TO: Jeff Watson, Community Development Services  
FROM: Christina Wollman, Planner II  
DATE: September 3, 2013 CW  
SUBJECT: Suebert BL-13-00020

The Public Works Department has reviewed the Request for Boundary Line Adjustment Application. In order to ensure that it meets current Kittitas County Road Standards, the applicant needs to provide the following prior to final approval:

PROPOSED

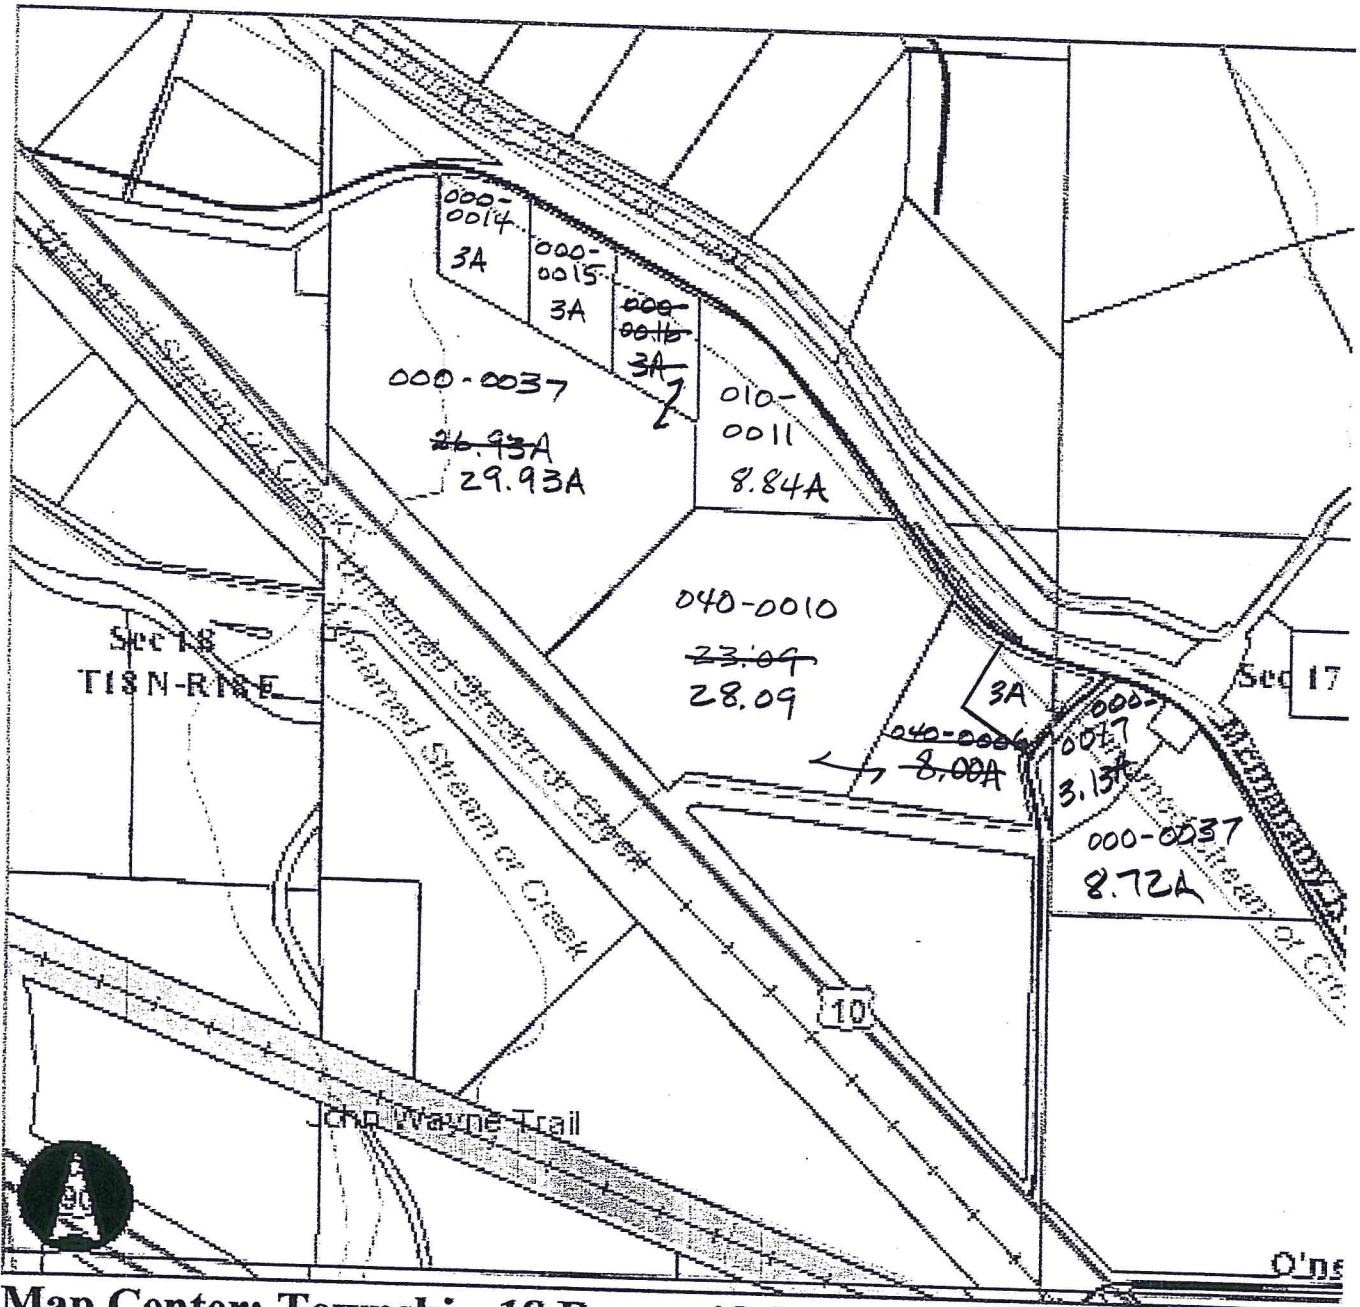
This one should be Ok. There is one proposed lot line that comes close to existing houses and outbuildings for the proposed 3 acre lot but it looks as though it should be far enough away from any existing wells.
